**Paul Freeman - RE: Proposed modification to Werris Creek Coal Mine**

**From:** Lindsay Fulloon <Lindsay.Fulloon@epa.nsw.gov.au>  
**To:** Paul Freeman <Paul.Freeman@planning.nsw.gov.au>  
**Date:** Monday, 13 August 2012 11:24 AM  
**Subject:** RE: Proposed modification to Werris Creek Coal Mine  
**CC:** Robert O'Hern <Robert.OHern@epa.nsw.gov.au>

I have reviewed the s.75W mod application submitted by Whitehaven Coal for the Werris Creek Coal Mine. I don't see any show stoppers from our (EPA – note OEH comments will be provided separately) perspective. However I have raised the following issues directly with Whitehaven following discussions and additional information that has come to light:

PLAN SHOWING AMENDED WERRIS CREEK COAL
BIODIVERSITY OFFSET AREAS FOR
- PROPOSED VWD1 AUGMENTATION
- ALTERNATE LOM EXPLOSIVE MAGAZINE LOCATION

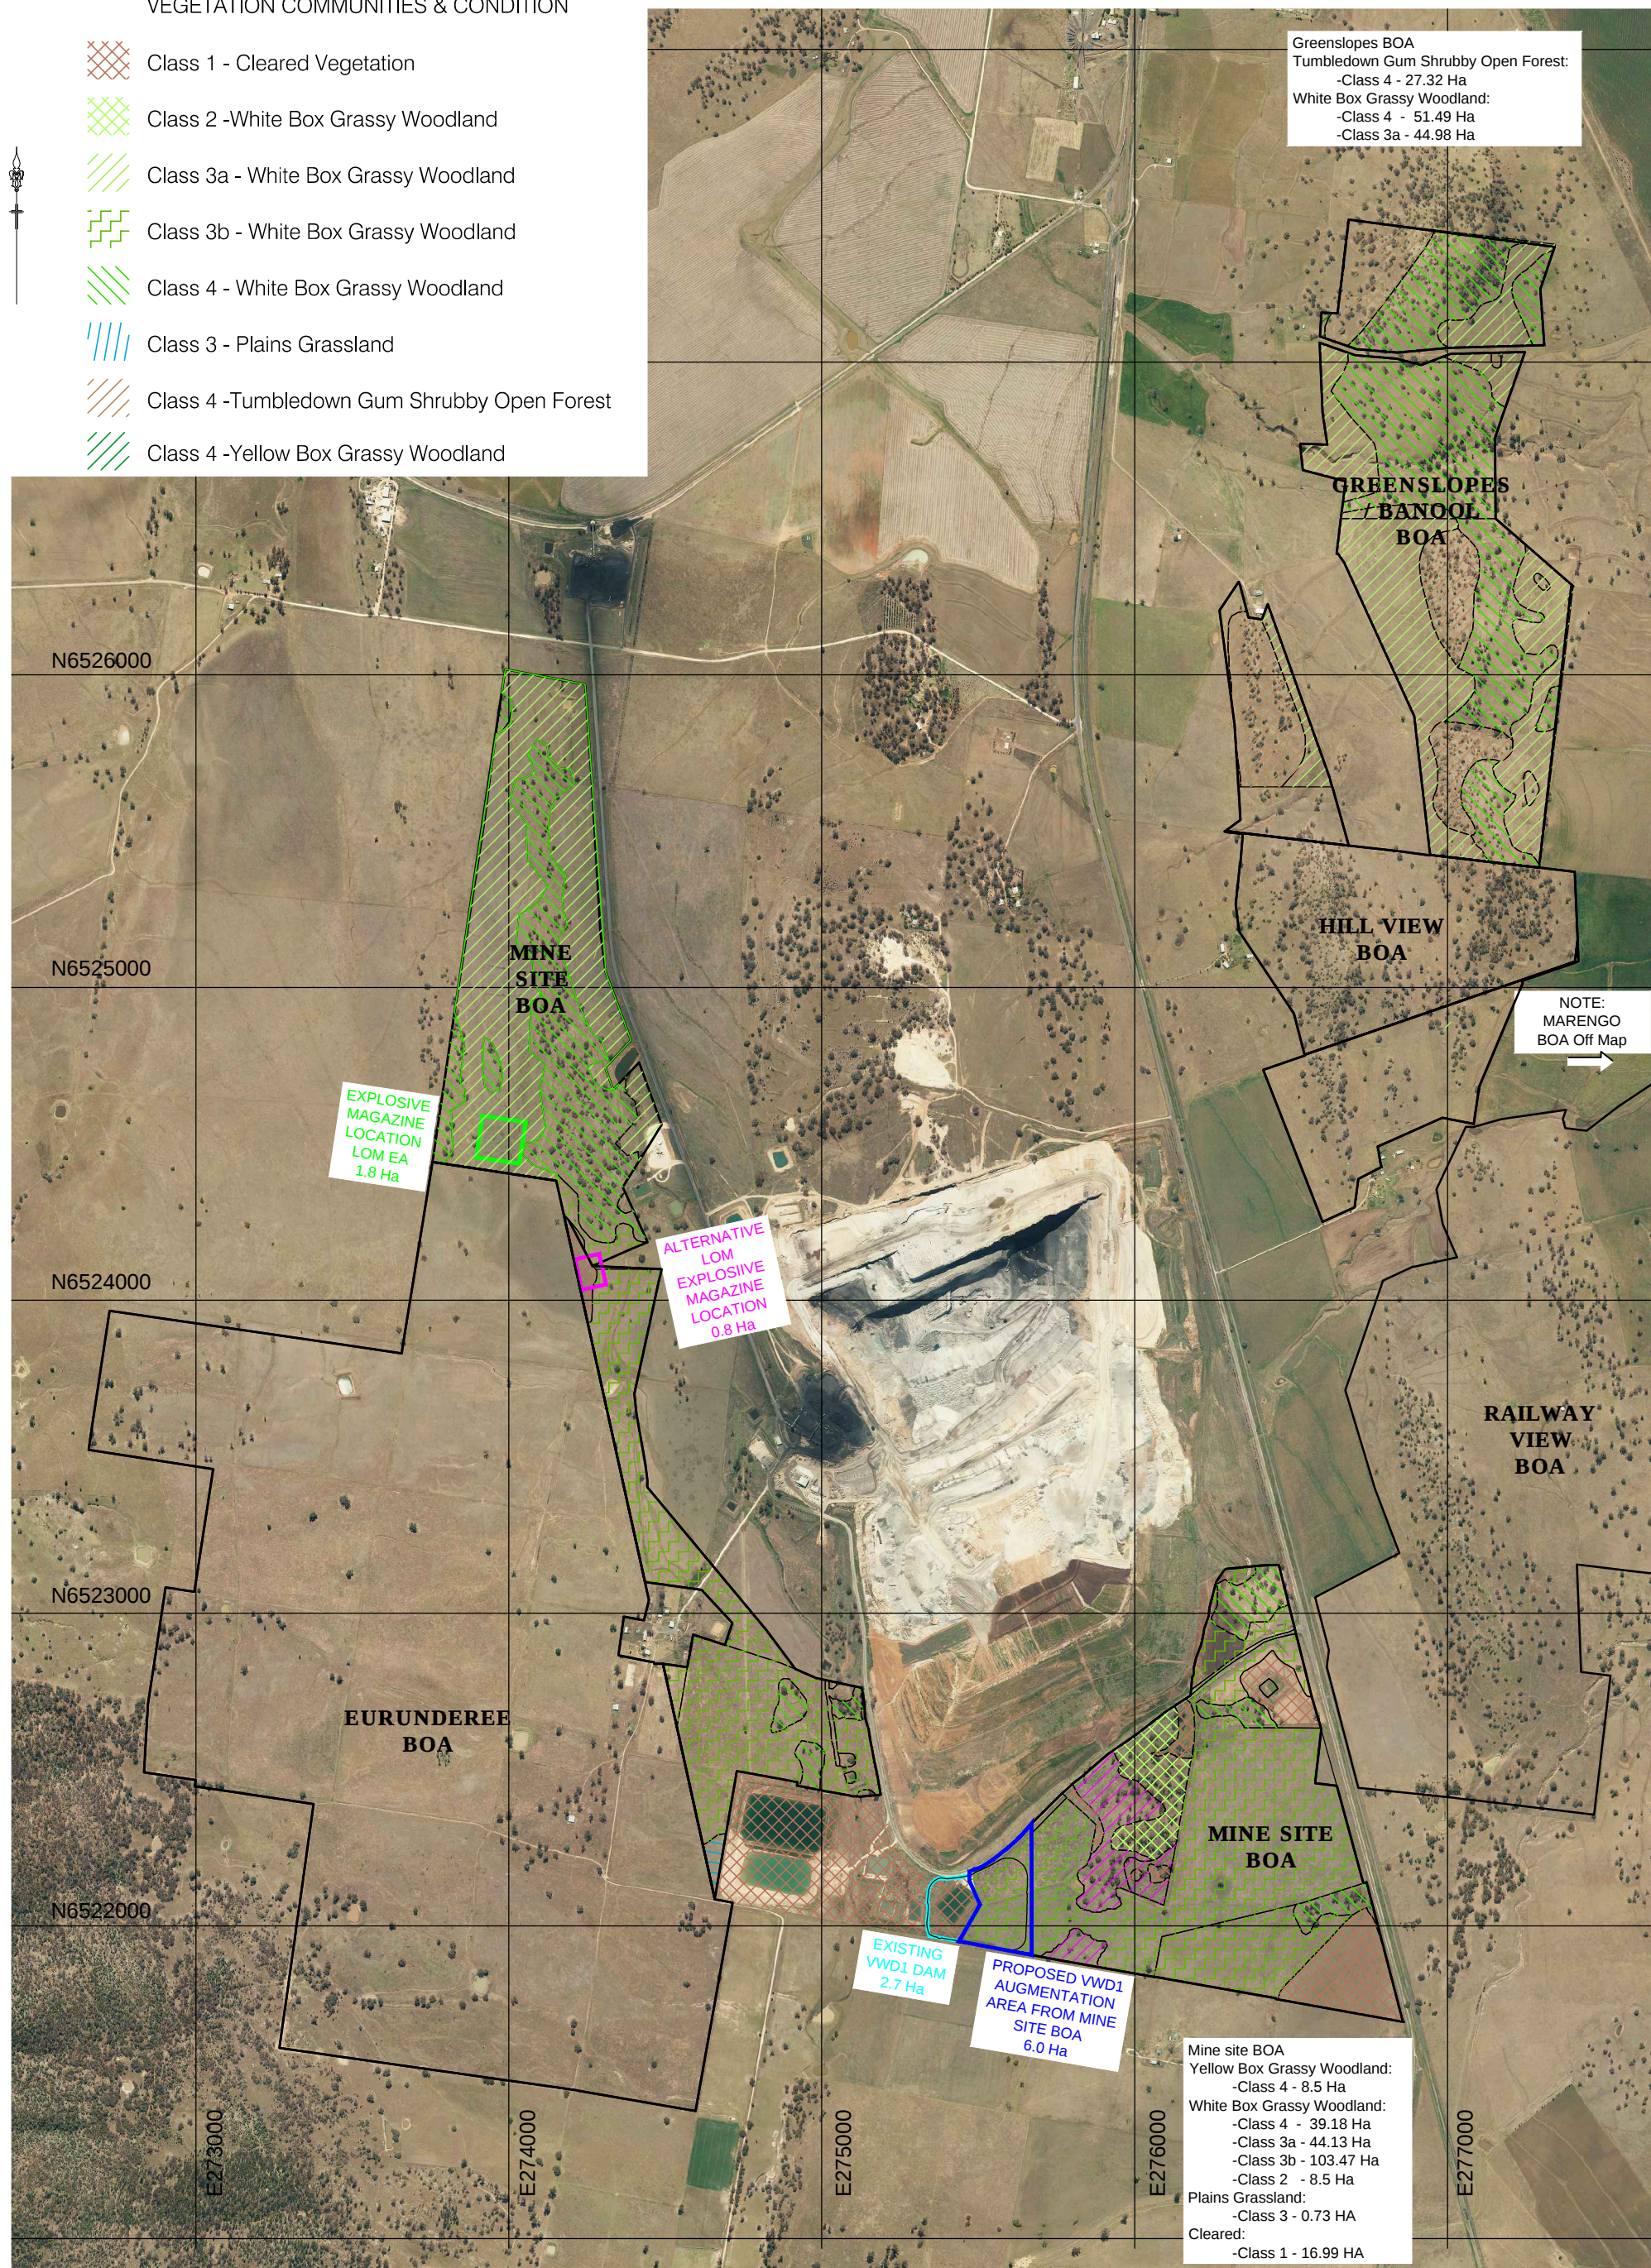
2. The EPA is also concerned that it now appears the two southern void water dam cells were not constructed to their full approved 400ML capacity, and in fact they can only currently hold around 280ML. We also understand that the northern cell is currently empty and that it could potentially therefore be subjected to corrective works to resolve the design capacity issue and ensure it is constructed to specification. If these ponds had been constructed to specification, the spill event that EPA is currently investigating may also have not occurred, and Werris Creek Coal would potentially be able to accommodate the water currently stored within the mine void.

3. The EPA expects that Werris Creek Coal will proactively implement all practicable additional void water management controls (e.g. increased usage options, evaporators, alternative storage, reworking existing storages to ensure they meet design specification, or a combination of these) to cater for contingencies such as significant additional rainfall prior to the completion of the augmented void water dam, or a delayed modification approval.
